Based off the new survey showing the extent of the front porch, we can move forward with this application for 154 CREPE MYRTLE LANE. The new home will not be able to extend anymore forward or rearward from what the survey is showing. An as-built survey will be required to confirm this before CO. let me know if you have any questions.

Columbus Platt
154 Crepe Myrtle Ln
Erwin NC

154 Creeper Myrtle Ln
Erwin NC 28339

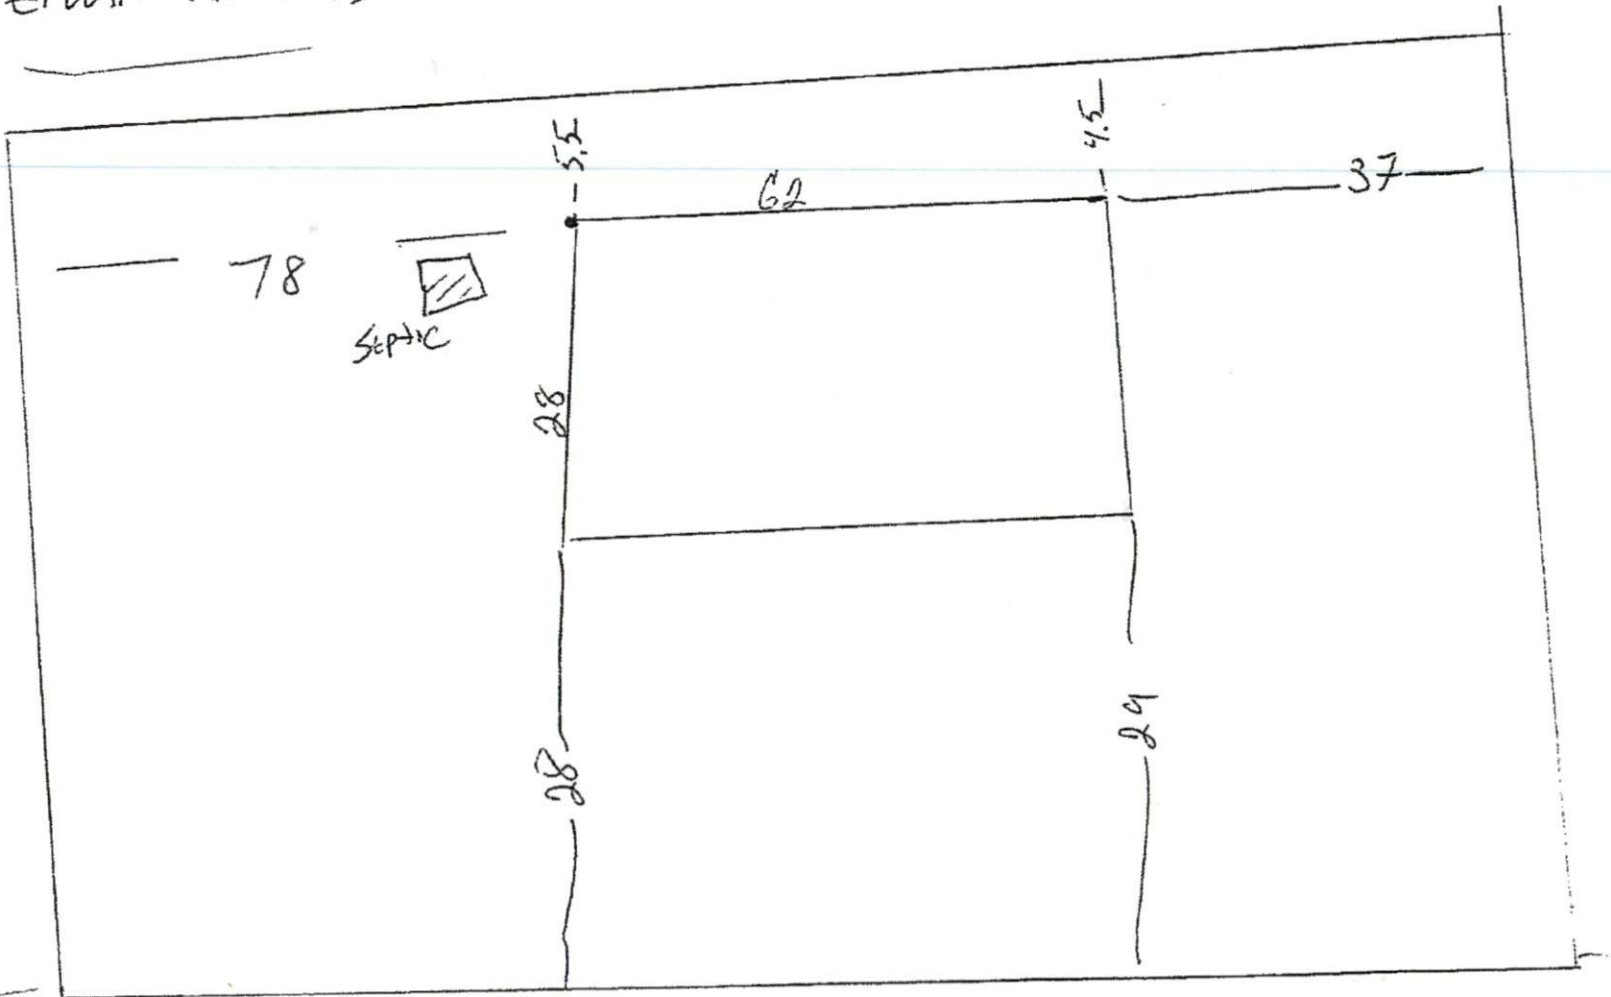
His measurements will need to match the survey – ie, no less than 5.09' and 4.09' in the rear and 27.32' in the front.
